BE/8/22/L

Dove Cottage 76 North Bersted Street Bersted PO22 9AQ

Erection of single storey rear conservatory. (This application may affect the character and appearance of the North Bersted Conservation Area and a Listed Building).

Elevation view of proposed conservatory

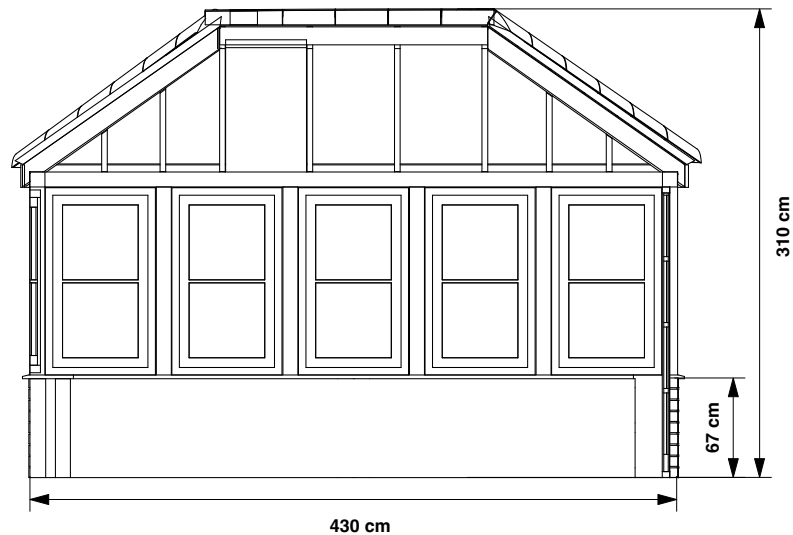
Whilst elevation and floor plans have been provided it is not clear what glazing system will be used for the proposed windows. Details of the cross section of the frame, glazing bars, etc and method of glazing should be provided to the LPA (and to an appropriate scale). Likewise, it is suggested that details of the proposed brick/mortar, and a sample panel of the flintwork be provided.
